**Your ref:** 3/2021/0731  
**Our ref:** DC/21/3238  
**Date:** 09-AUG-21

**Location: St James C of E Primary School Greenacre Street Clitheroe BB7 1ED**  
**Proposal: Redevelopment of the existing educational facility**

With regards to the above development proposal, United Utilities Water Limited ('United Utilities') wishes to provide the following comments.

## SEWER RECORDS

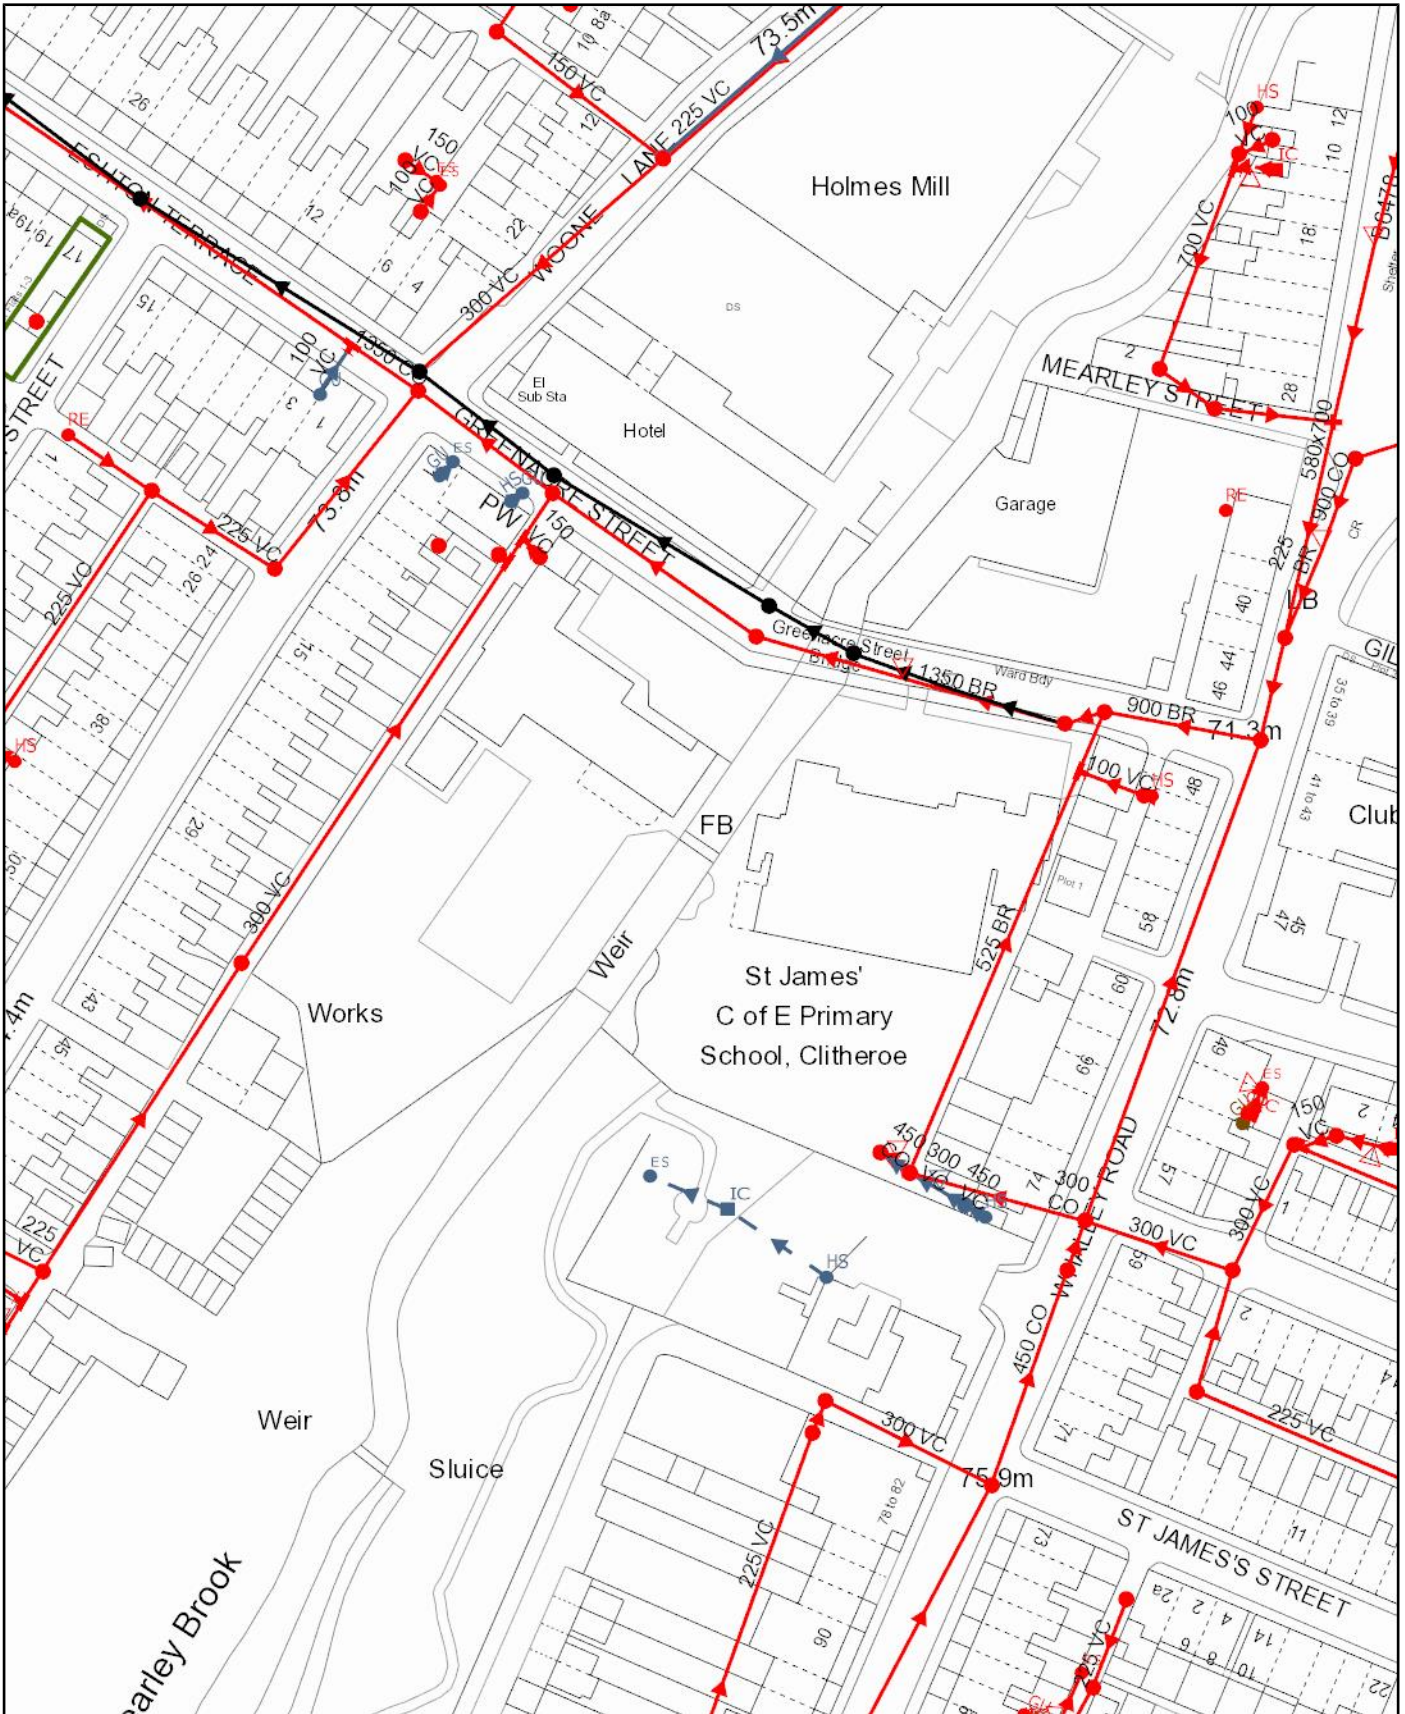
**A public sewer crosses this site and we may not permit building over it. We will require an access strip width of 7 metres, 3.5 metres either side of the centre line of the sewer which is in accordance with the minimum distances specified in the current issue of Part H of the Building Regulations, for maintenance or replacement. Therefore a modification of the site layout may be necessary.**

**Deep rooted shrubs and trees should not be planted in the vicinity of the public sewer and overflow systems.**
